WINDERMERE PRELIMINARY PLAN

E 1/2 OF SECTION 29, T13S, R65W OF THE 6TH P.M.
EL PASO COUNTY, COLORADO

See comment letter.
Provide all Preliminary Plan checklist items.

SP19003-V2-PrelimPlan redlines.pdf Markup Summary 8-20-2020

OVERALL SITE PHASE PLAN

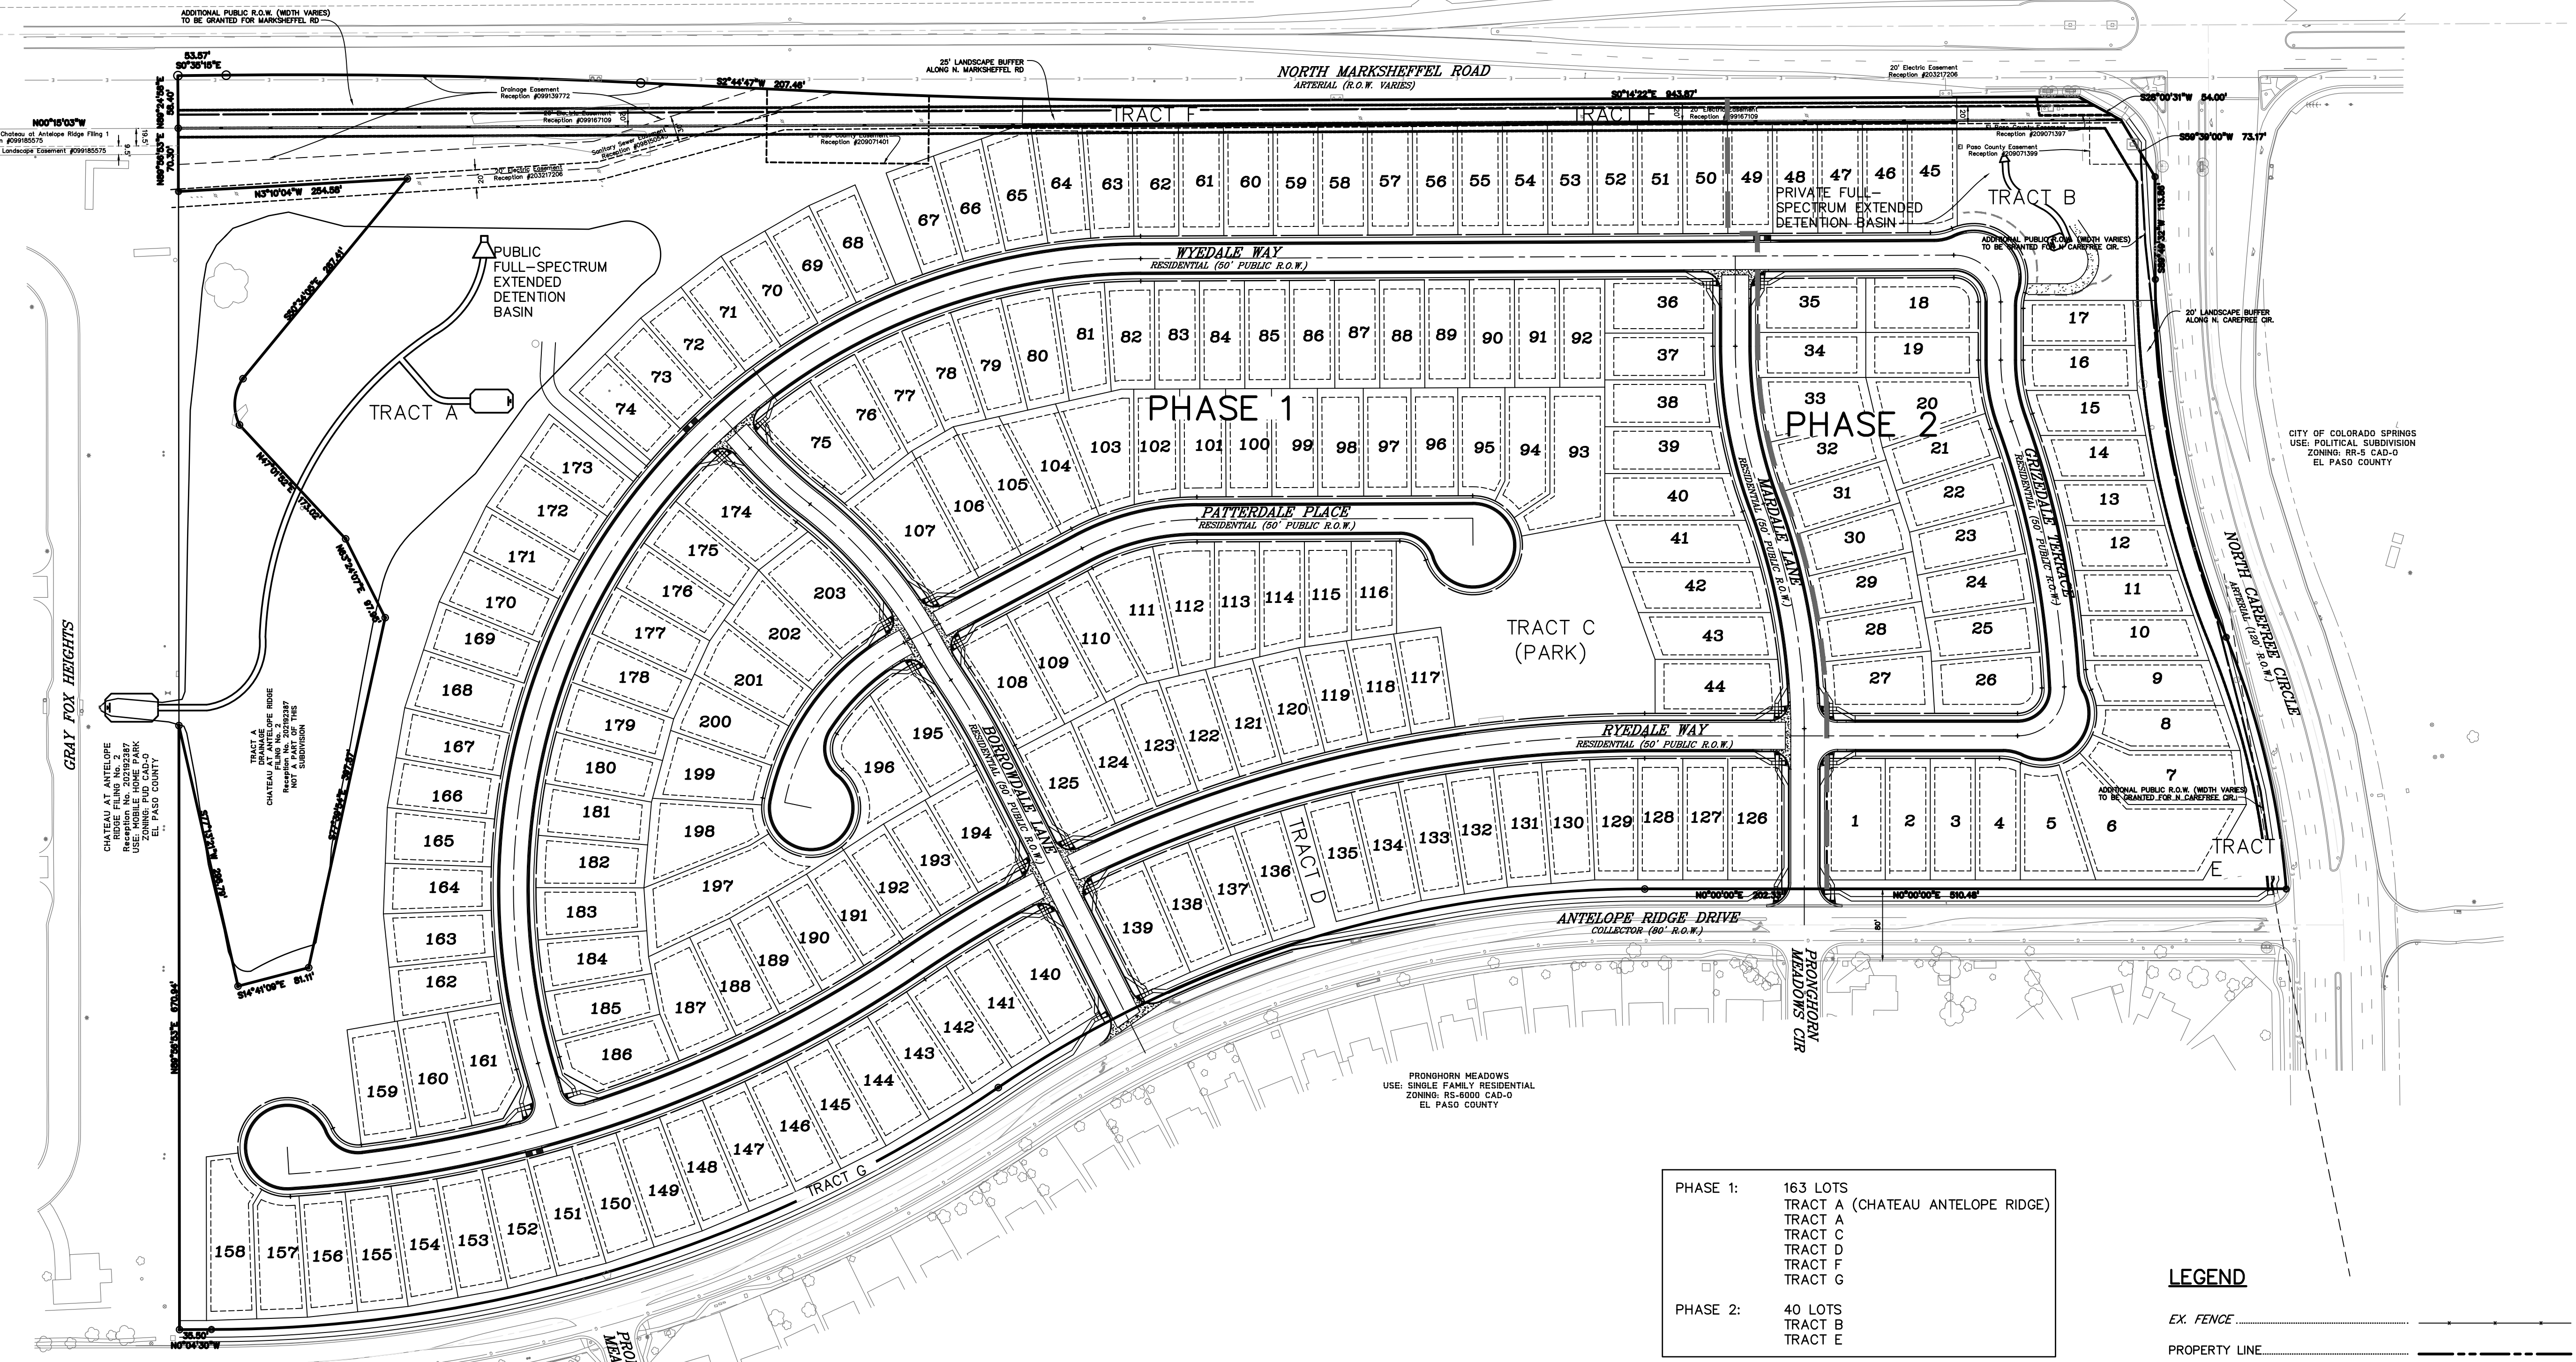
Dimension the ROW dedication and total width at applicable locations. This doesn't match MTCP.

wall can't be in the ROW

Show the adjacent property/ROW lines

adj landuses, zoning, city verses county all sheets all sides

remove phases you already have a sheet dedicated to that

wall can't be in the ROW

Dimension the ROW dedication and total width at applicable locations. This doesn't match MTCP.

PRELIMINARY
GRADING PLAN

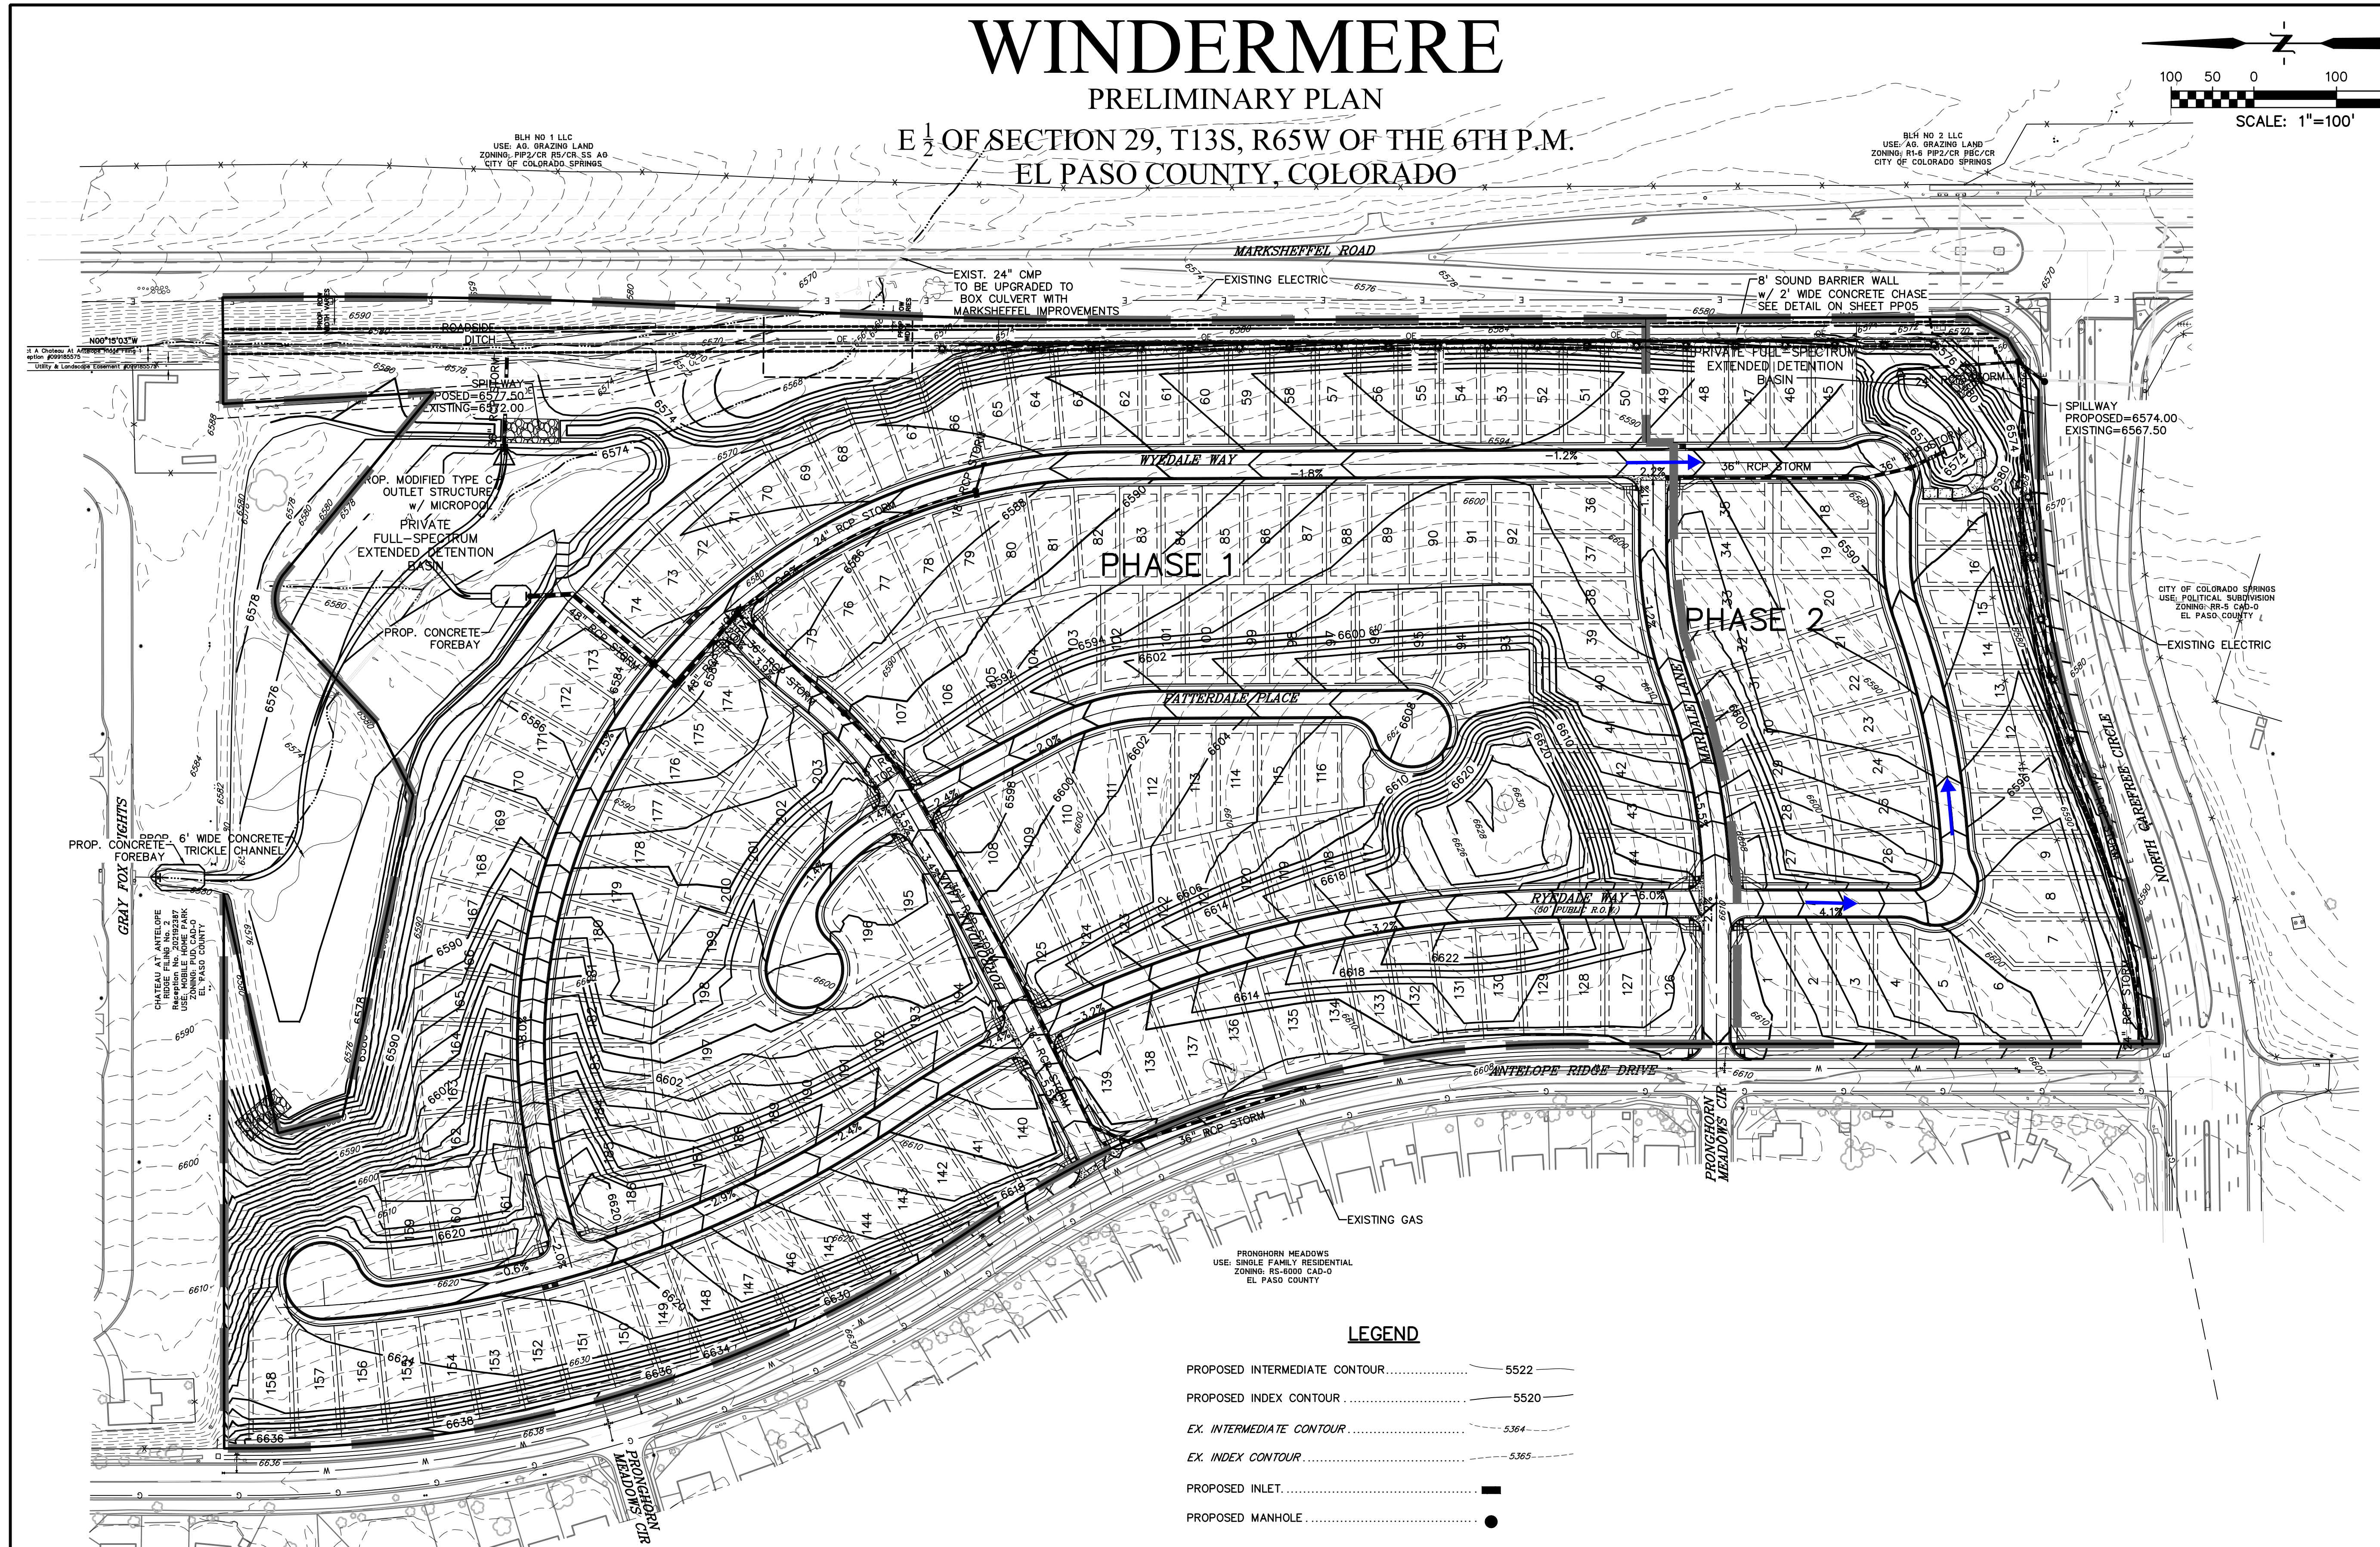
Label all drainage facilities.

show sound wall on plan and provide details so grading and drainage work

Grading in County easement not allowed:

PP08

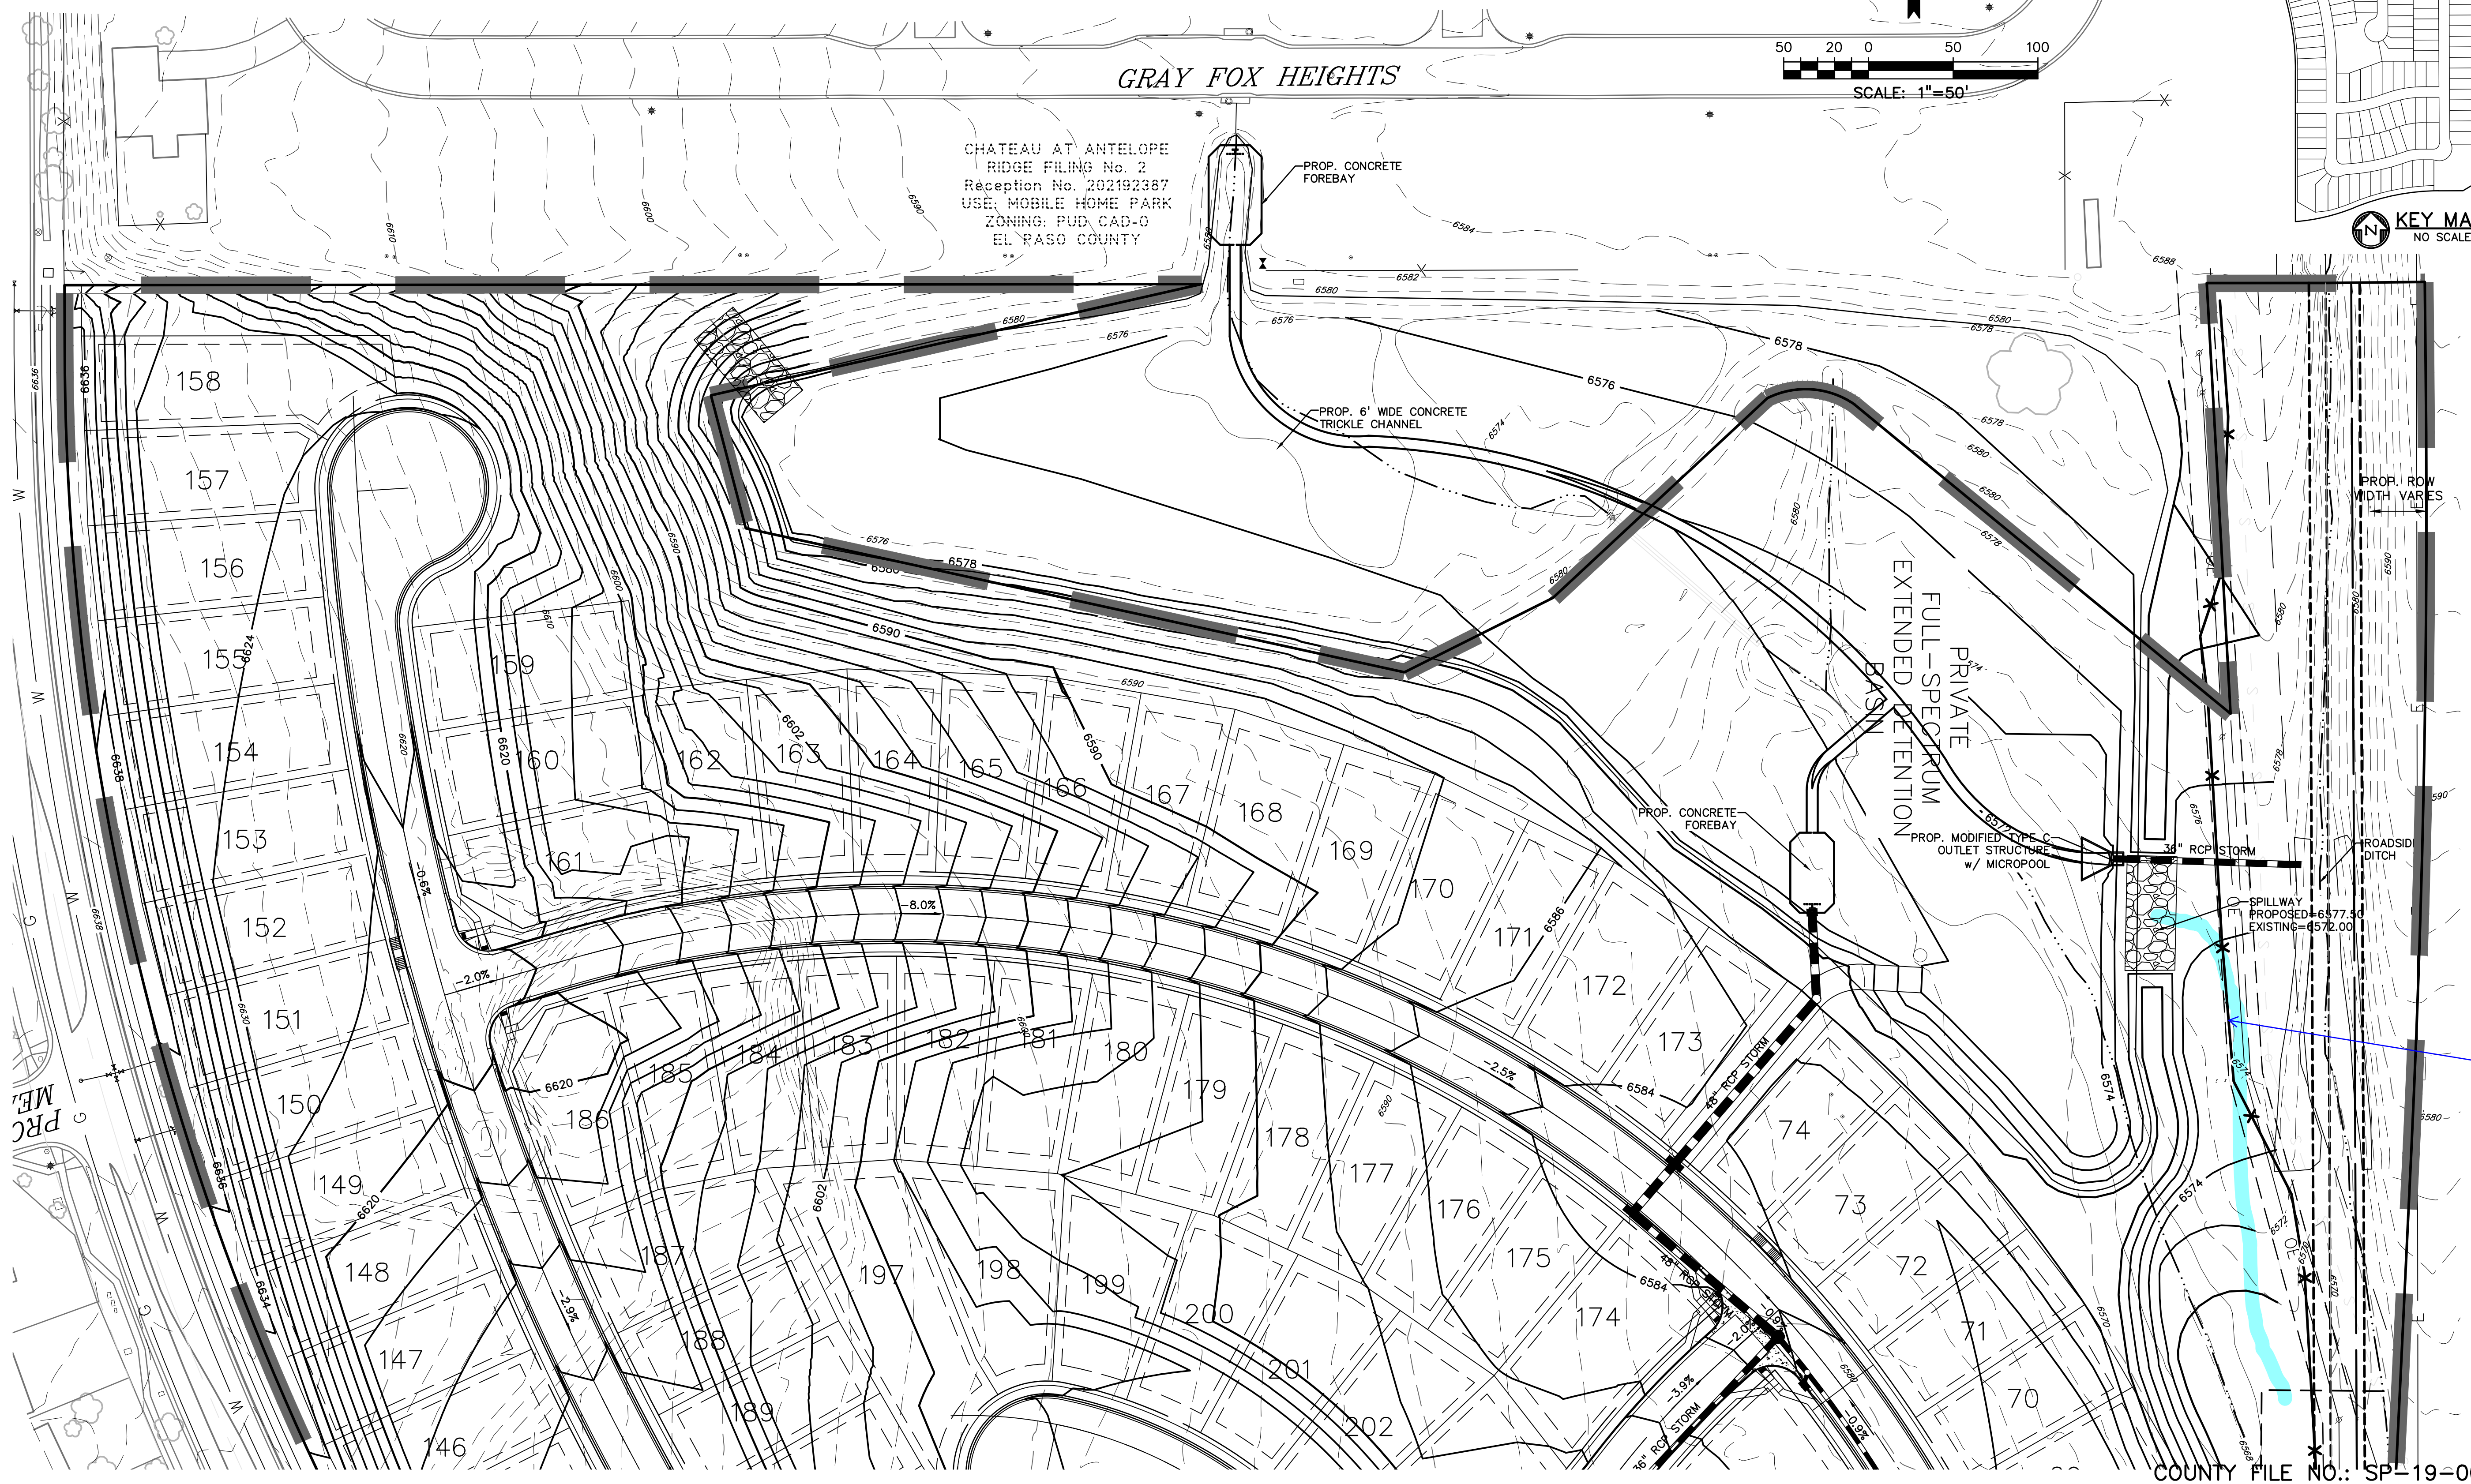
PREPARED UNDER MY DIRECT SUPERVISION FOR AND ON BEHALF OF DREXEL, BARRELL & CO.
 Show existing flowpath. Provide a design that conveys all flows properly. No grading in County easement.

Adjust layers to match these

Address this area

Show the whole site

Label all existing and proposed facilities

Show existing flowpath. Provide a design that conveys all flows properly. No grading in County easement.
